A47 DUALLING – NORTH TUDDENHAM TO EASTON

Scheme no. TR010038

APPENDICES C and D to FURTHER
TRANSPORT SUBMISSIONS in response
to Deadline 6 submissions

Appendices C and D to Further Transport Submissions in
response to Deadline 6 submissions

# PROPOSED WOOD LANE JUNCTION

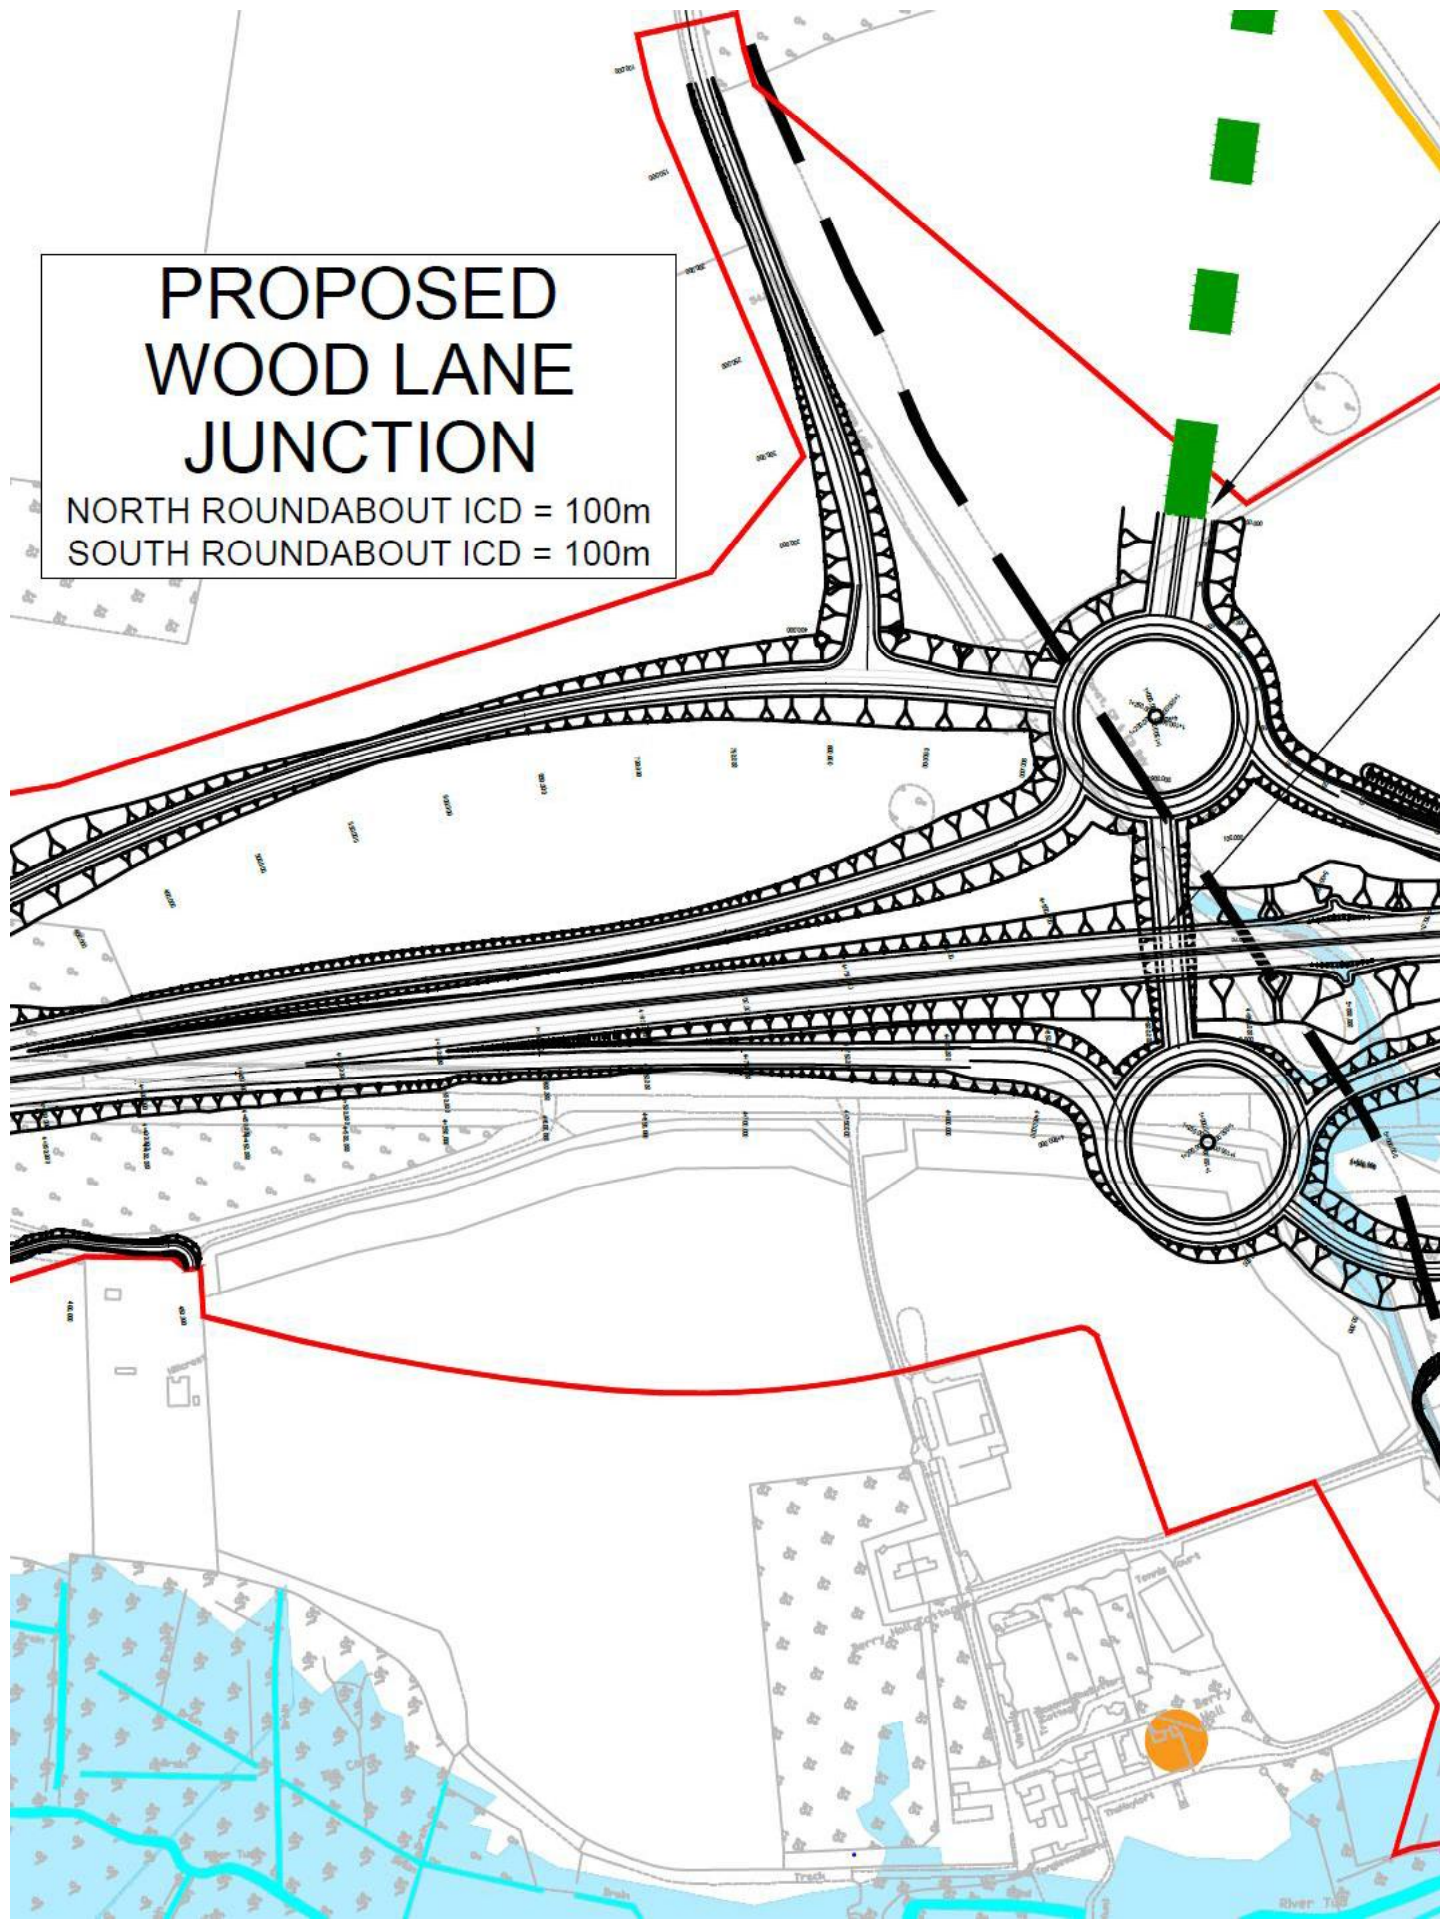
4. Further, it is evident that the slope coefficient which determines the increase in capacity derived from an increase in the ICD, is virtually flat for a roundabout at 80m ICD and above (see AppD 56) so there will be very little capacity benefit from an increase from 80m to 100m.

5. The Applicant's clearest explanation of its design process for the roundabouts at the Wood Lane Junction is in its Junction and Sideroad Strategy of 5 February 2020 (at its website for the project under 2020 consultation documents) at para 2.4 where it confirms two roundabouts were proposed at PCF stage 2 and initially designed as the preferred option. It states then "The inscribed circle diameter (ICD) was increased to 100m diameter (the maximum recommended in DMRB CD116) to assess the predicted traffic flows" and goes on to say "The Ratio of Flow to Capacity (RFC) and maximum queue length from ARCADY are the two primary measures of junction-arm performance for a roundabout." While the second part of the last sentence accords with the conclusions in the above reports, what the Applicant does no mention is that it is the entry widths and flare lengths that determine the performance, not to any great degree in a large roundabout as we have seen, the ICD.

7. ACM believes in light of the Applicant's suggestion at Deadline 6 to reduce the south dumbbell from 100m to 80m ICD, that it might assist the Ex A if it were to prepare a design for the junction before the end of the DCO process using, in conjunction with the current ARCADY software, a steps plan on the lines recommended by Kimber in TRL LR942 and to start with assessing true values for as yet undesigned factors there described (entry width, Flare length and half approach distance) (AppD 61) in order
